From: Simon Davis
Sent: 29 September 2017 11:02
To: Planning.Responses
Subject: FW: BE/71/17/PL - Wickes, Bognor Drainage Scheme

From: Paul Cann
Sent: 28 September 2017 15:09
To: 'Tim Rainbird'
Cc: Simon Davis; Tom Woolner
Subject: RE: BE/71/17/PL - Wickes, Bognor Drainage Scheme

Comments on revised proposals;

SW PACKAGE PUMP

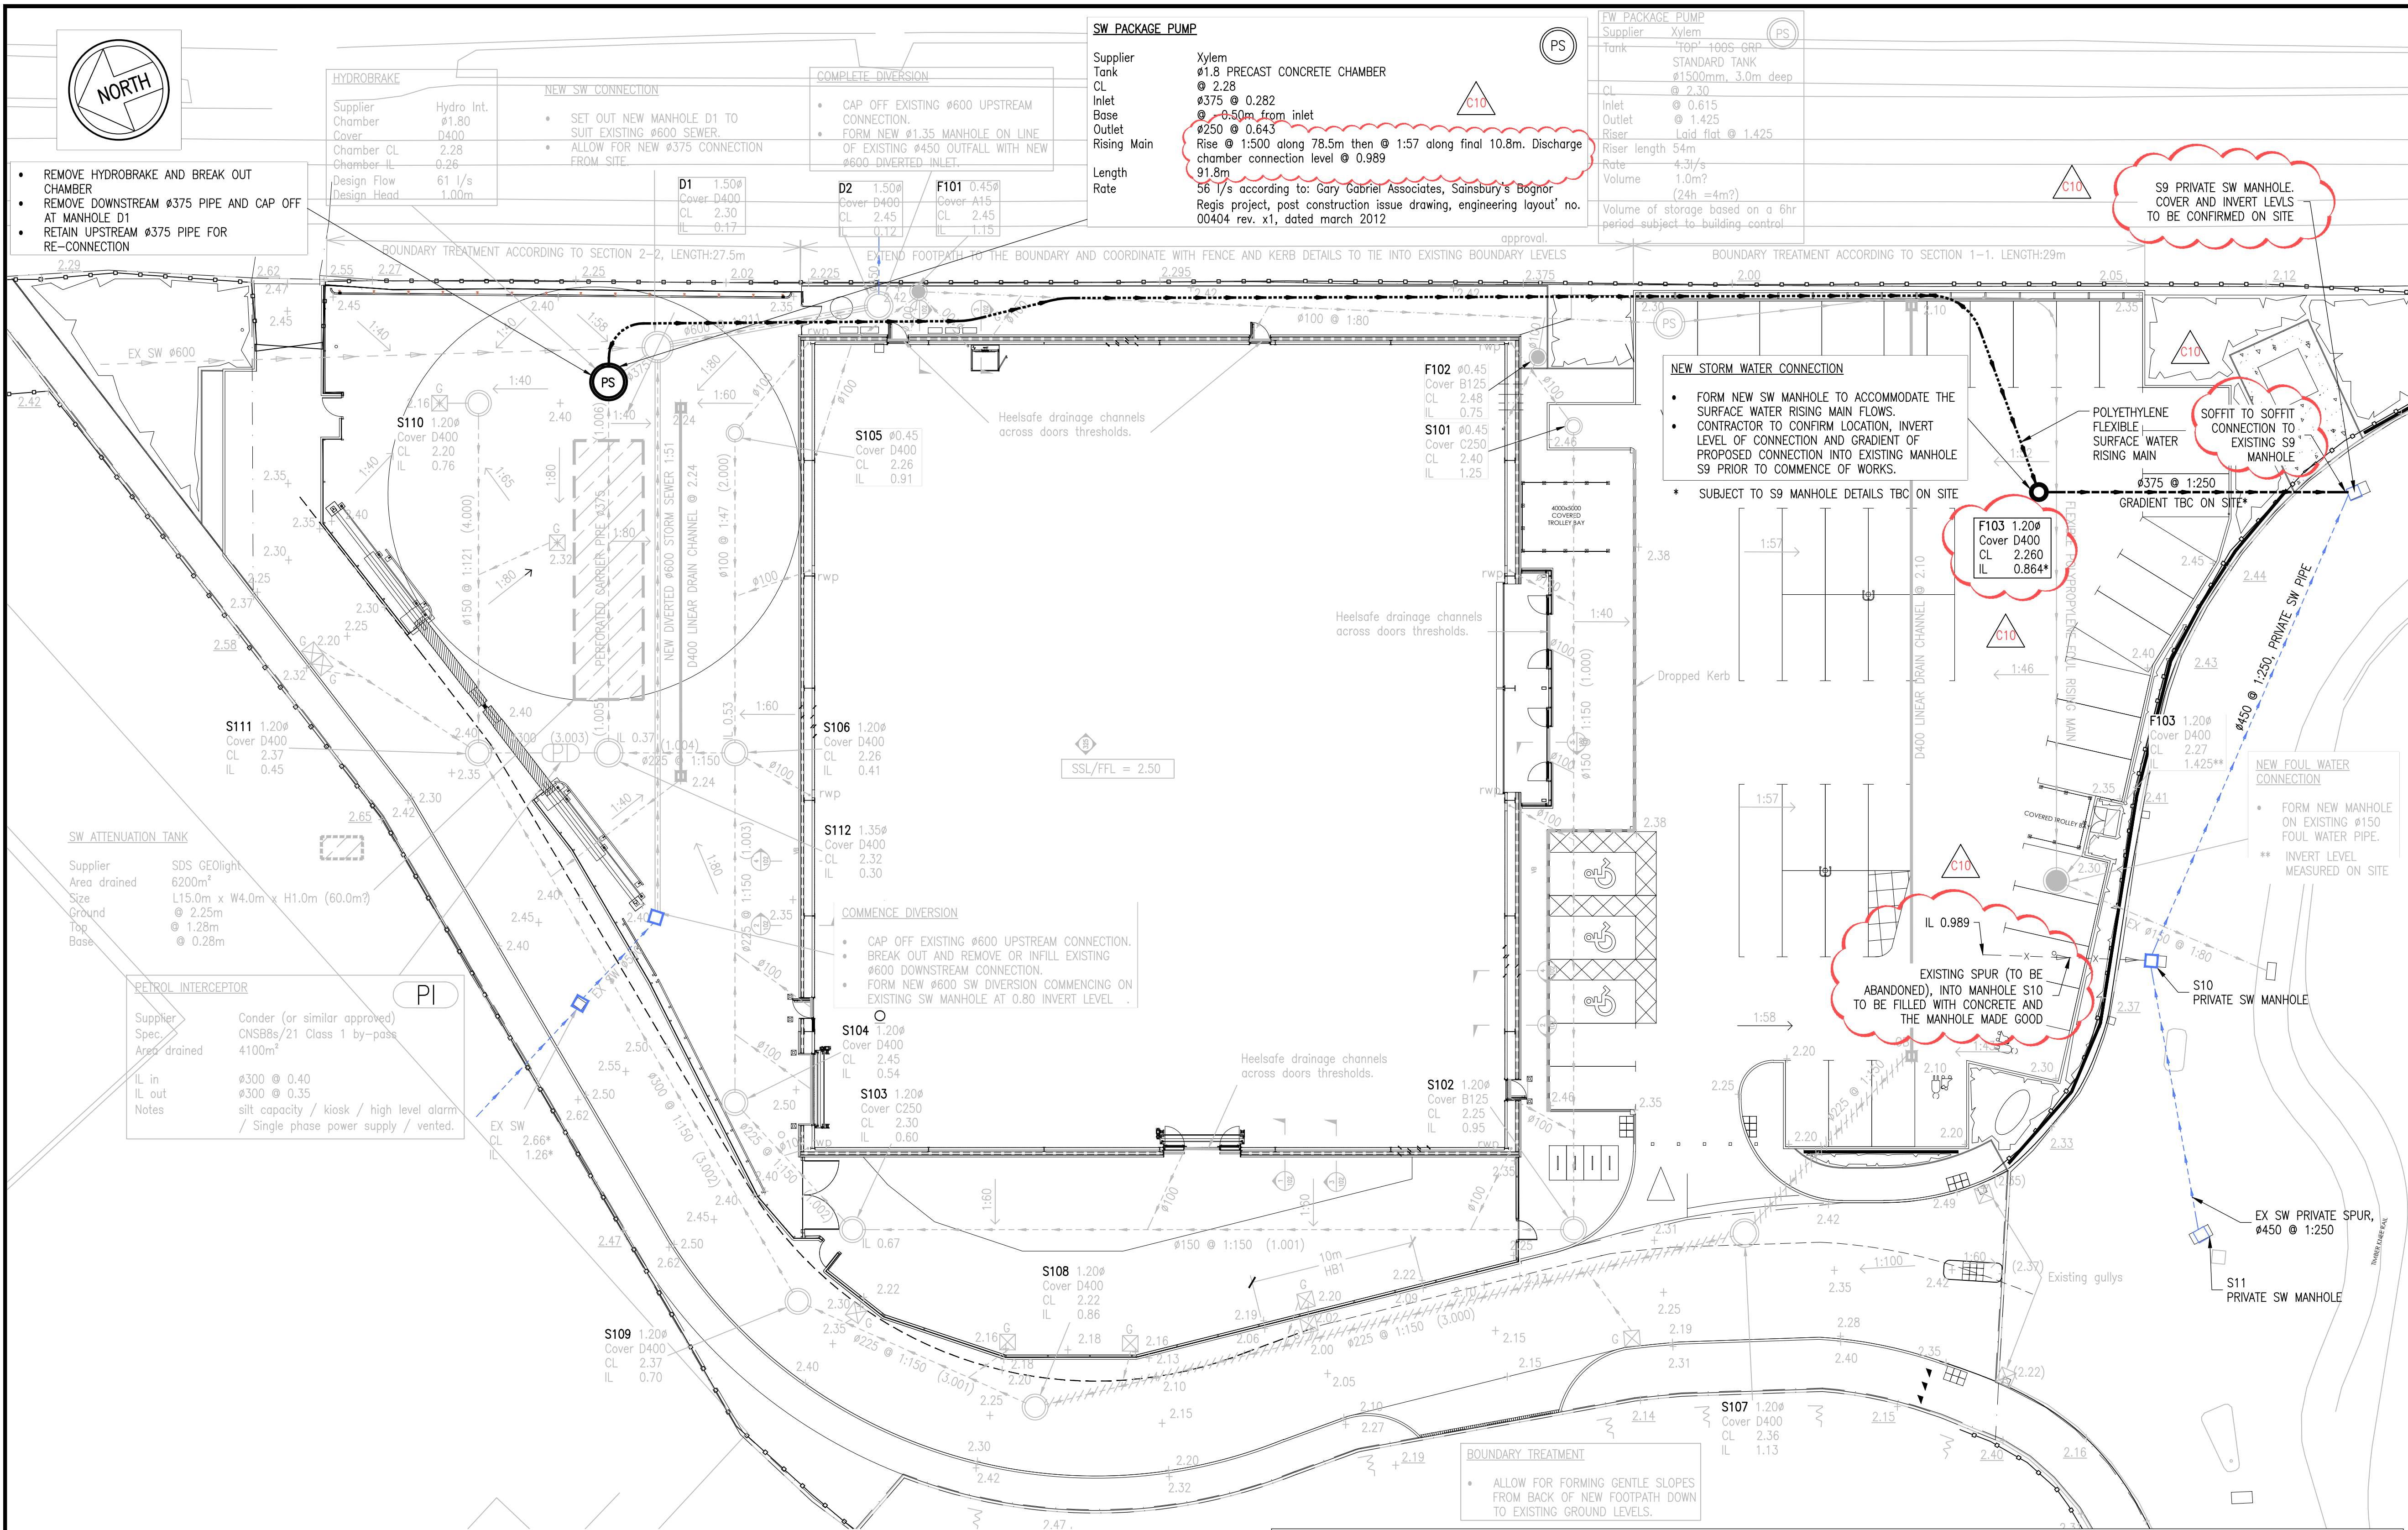
1. Connection to manhole S9 to be made at soffit to soffit level. Specify connection invert level/invert level of existing 450mm pipe.
2. Specify invert levels in discharge chamber. ie. 0.989 if intending to lay it flat, as per notes? A gradual rise would be preferred though.
3. The construction detail for the discharge chamber refers to existing manhole S9 and a 450mm outlet pipe. This is not the case. It should show a 250mm diameter rising main with a 375mm diameter outlet. There are some spelling errors too.
4. Improve angle of discharge of the rising main into the discharge chamber ie. not 90 degrees.
5. Existing spur (to be abandoned) into manhole S10 to be filled with concrete and the manhole made good. Add note.
